Our reference: P-903733-NIN2
Contact: Sandra Fagan
Telephone: (02) 4732 7992

7 May 2025

Council Advice on Response to Submissions – SSD-30871587 – Proposed Warehouse and Distribution Centre at 805-817 Mamre Road, Kemps Creek, NSW, 2178

Figure 1 Typical section – OSER

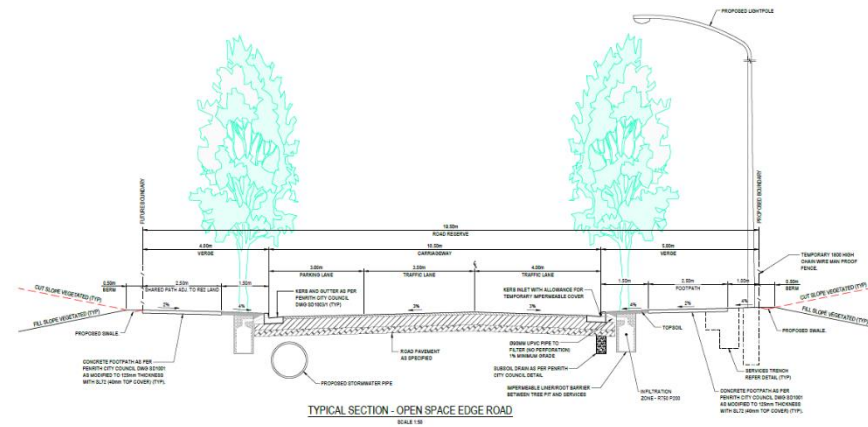
- c) It is understood that the applicant has been liaising with Council's City Planning Team regarding the Open Space Edge Road (OSER). Please refer to the City Planning comments below in relation to this.

- a) The land dedication plan differs from the last version which was consulted with Council's City Planning department. Council have not been consulted about the dedication plan / Open Space Edge Road (OSER) as per the plans lodged with this RTS. In the previous versions reviewed by the City Planning team, the OSER encroached onto REI zoned land in small sections and only where it was unavoidable. However, in the updated version, the proponent has shifted the alignment of the OSER so it would encroach onto REI zoned land by 4m consistently along the site. This would require the entire road corridor to be shifted, which would not be possible in certain sections due to the location of Sydney Water's basins. The plans should be amended to show that the full extent of the OSER is located primarily on IN1 zoned land consistent with the last dedication plan sent to Council on 20 February 2025.

Figure 16 Proposed plan of subdivision

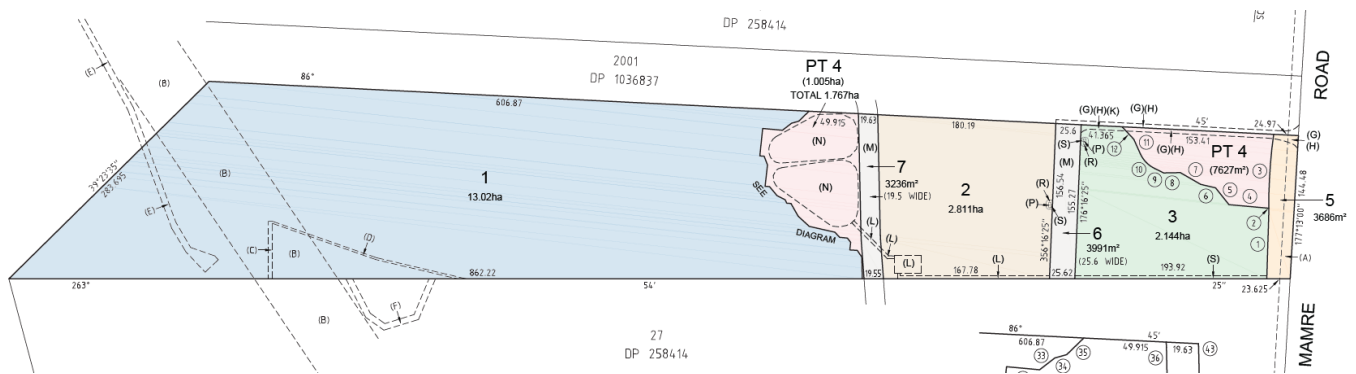
- g) The subdivision plan shall be updated to note that the collector road, is to be dedicated to Council as public road.
- h) If/when the application is approved, a condition of consent shall be applied to state that the collector road is to be dedicated to Council free of cost.

Figure 18 Warehouse 2 site layout

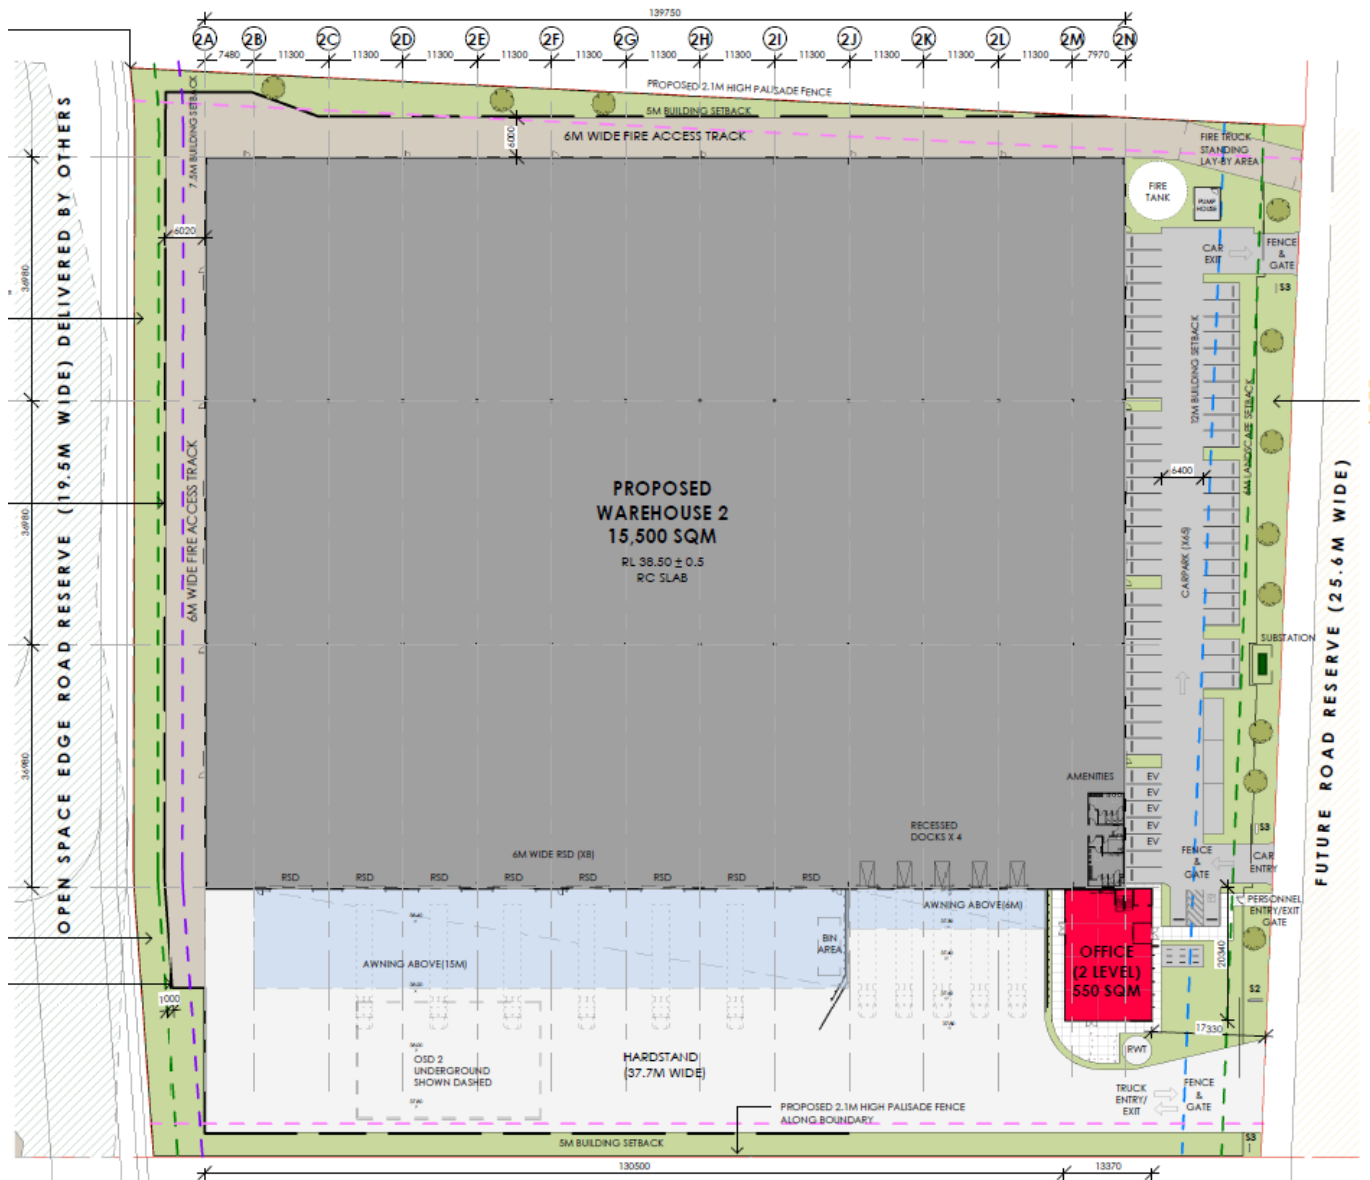
land. Warehouse 2 appears to turn its back to the adjoining OSER and the open space beyond, and the landscaping along the western building alignment appears narrow as a road interface, particularly where the levels change in the south-western corner.

- b) The western elevation of warehouse 2 currently represents a poor address to adjoining public spaces, that could result in undue safety and security risks. The plans should be amended to address and provide passive and active surveillance opportunities from the western elevation of warehouse 2 over the adjoining public spaces (OSER and REI land).
